Project Name: Harborview Townhomes: New building comprising 7 residential units

Project ID: 2011-214

Project Address: 127 York Street (aka 121-129 York Street)

I refer to recent discussions regarding the design of the 6 foot high privacy fence around three sides of the site of the proposed new building and am writing to document the current position re site plan approval.

5 FENCE FROM NEIGHBOR'S PROPERTY
NOT TO SCALE

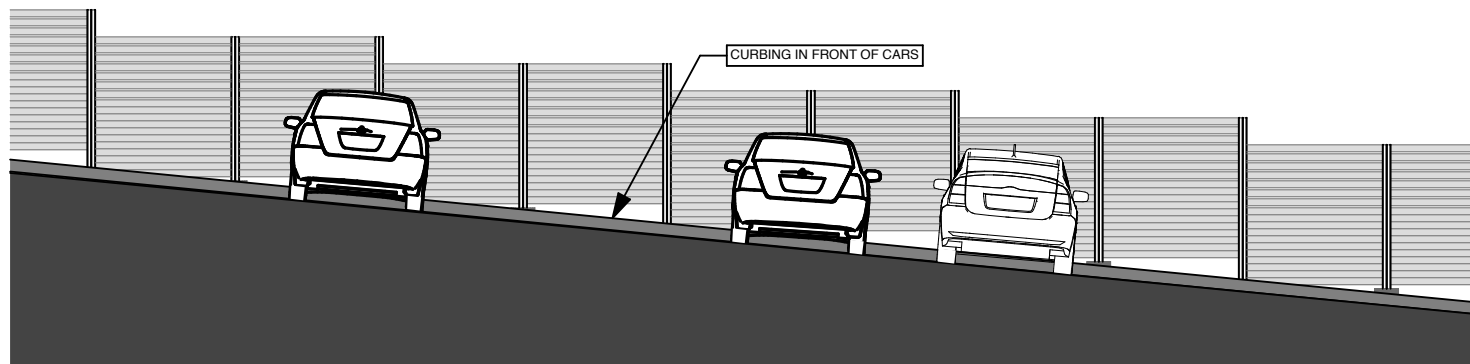
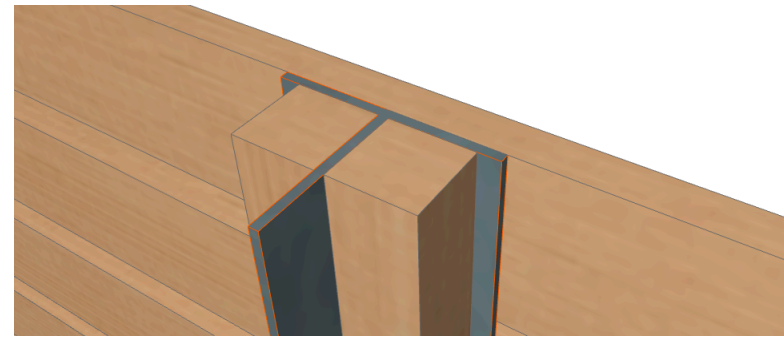
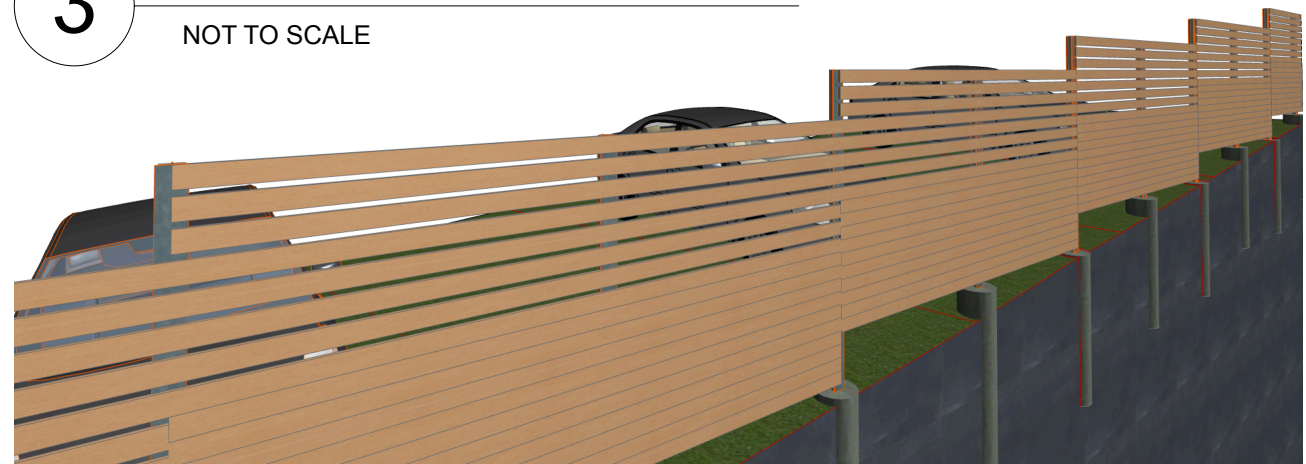
In April, 2012 staff were made aware of the fact that the fence detail approved by the Planning Board in 2011 was inconsistent with the design theme that had been developed by the architects for the building. Although a number of alternatives to the approved fence detail appeared feasible, Soren Deniord requested that your team be given more time to develop a design that met both the aesthetic and functional objectives. For this reason we agreed to approve final plans that show the original approved detail with an accompanying note that states "*Revised privacy fence detail to be submitted for review and approval prior to CO*" (reference detail 5 on L3.0 April 16, 2012, attached).

We request that any redesign of the fence detail address the functional objectives of the site plan requirements. One of the key objectives of the fencing around the proposed parking lot is to avoid the glare from car lights from intruding into neighbors windows and to screen the vehicles as viewed from adjacent properties, and therefore the section along the east side of the parking lot would need to be solid.

We would also request that any new fence detail be attractive from both sides of the fence and achieve some screening (as implied by "privacy" fence) between the residential windows of the proposed condo building and those of the surrounding residential buildings.
